Rezoning Transportation Analysis

Petition Number: 2019-179

Date	Description
01-15-2020	First Review
02-17-2020	Second Review
04-23-2020	Third Review
06-26-2020	Fourth Review (MM)

RZ-1.0

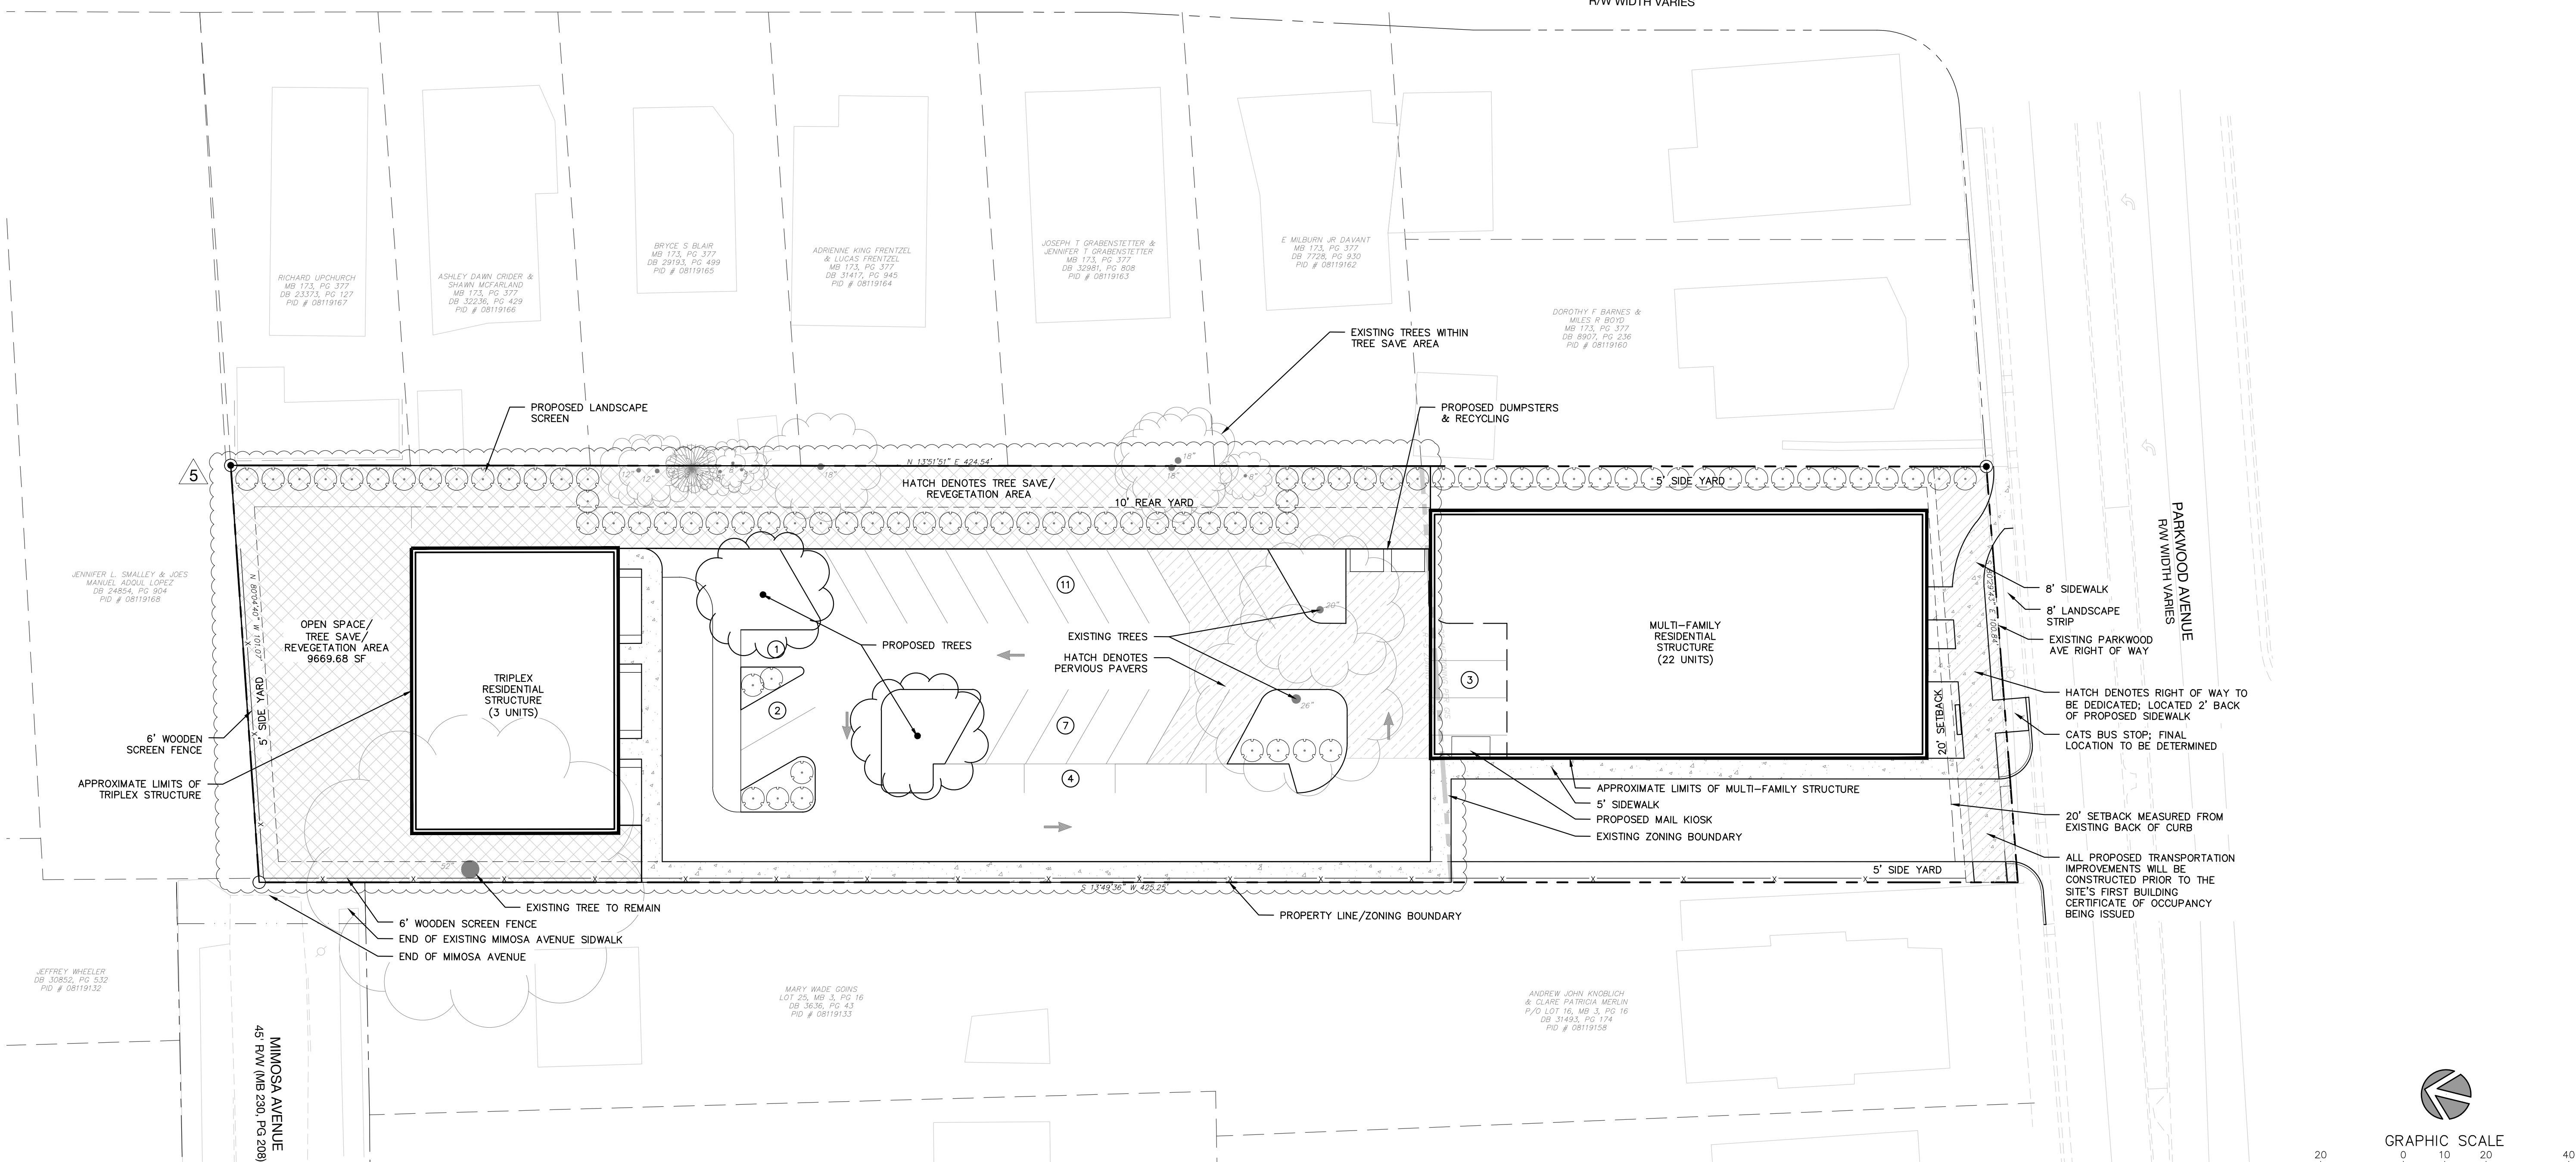
9. **Revised Comment based on site plan 04/14/2020:** Petitioner should revise the driveway to Mimosa Avenue to meet Charlotte Land Development Standards Manual for two-way circulation since it is a shared driveway.
